KITTITAS COUNTY

MEMORANDUM

TO: All Staff
FROM: Justin Turnbull, County Surveyor 
DATE: March 9, 2021
SUBJECT: 2nd County Survey Review of BL-20-00031 Ski Lifts

RECORD OF SURVEY
 A PORTION OF THE WEST 1/2 OF SECTION 15,
 TOWNSHIP 22 NORTH, RANGE 11 EAST, W.M., KITTITAS COUNTY, WASHINGTON

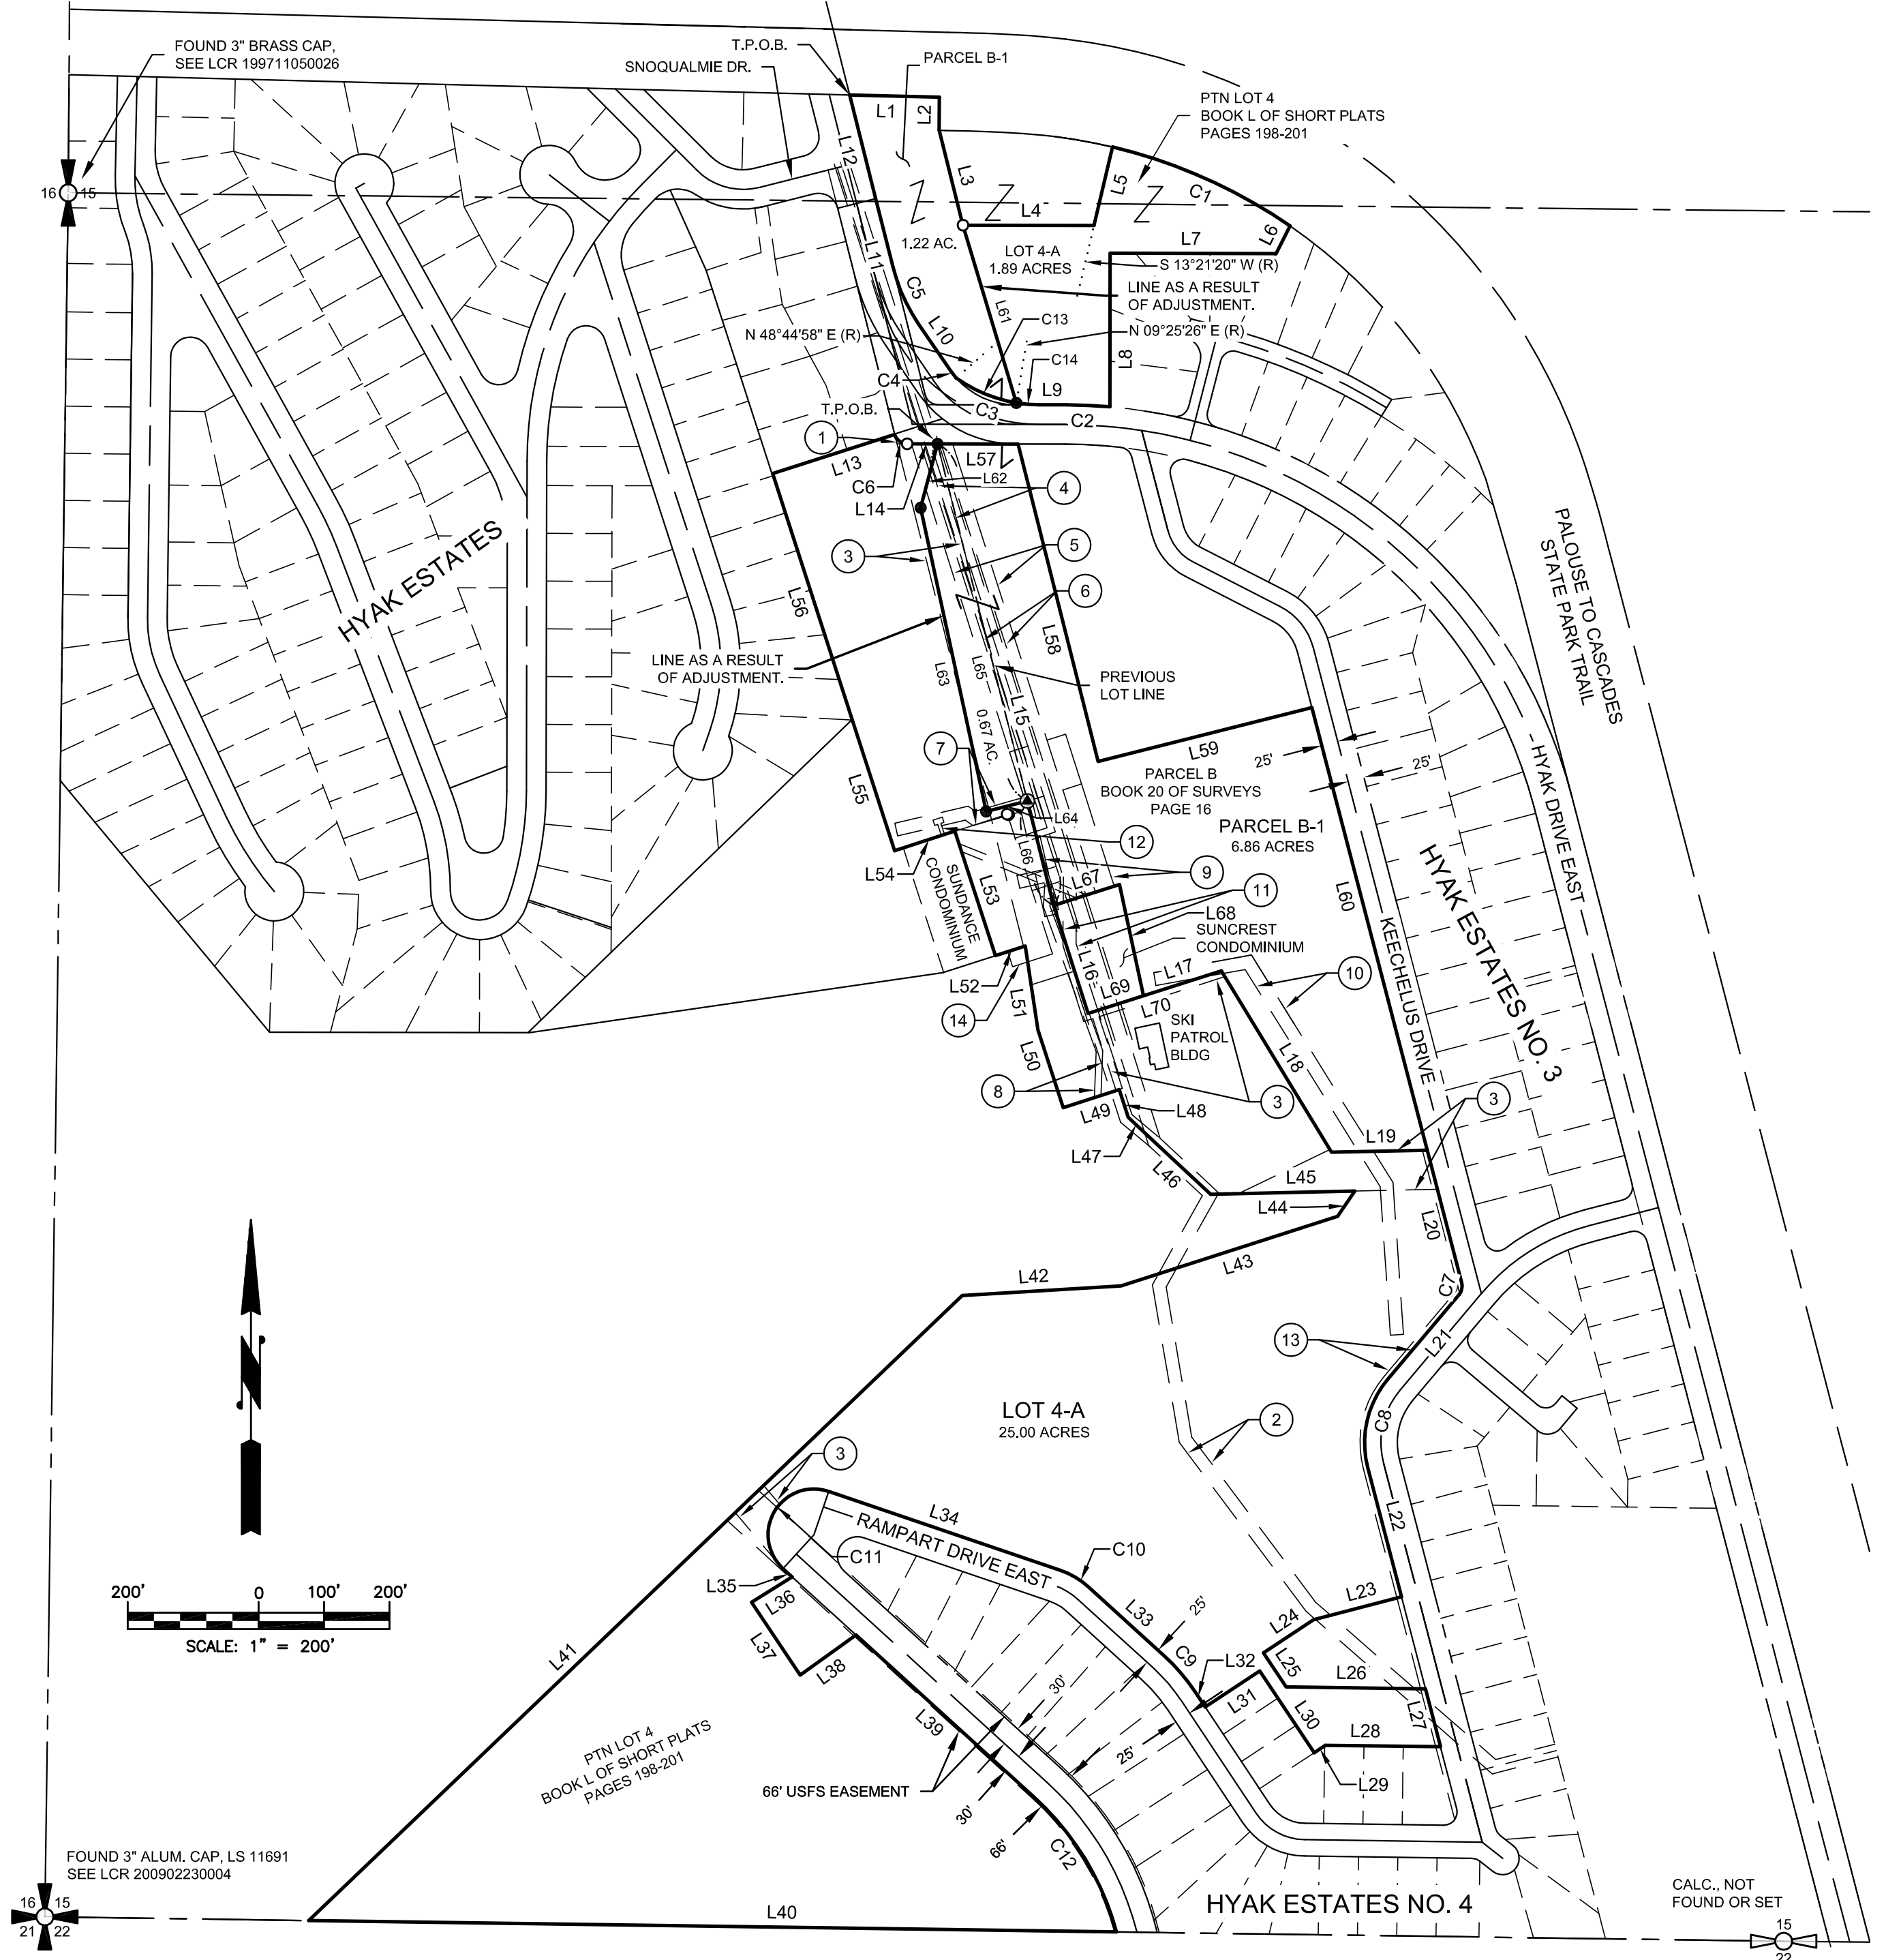
1. Please include the bearing and distances, along the basis of bearing, together with suitable ties to link the boundaries with the basis of bearing.
2. Please include roadway ownership and surfacing information. As this survey is already quite crowded, this could be achieved with a note.
(EX: roads X, Y and Z are paved county roads, falling within the 50' wide right of way shown.)
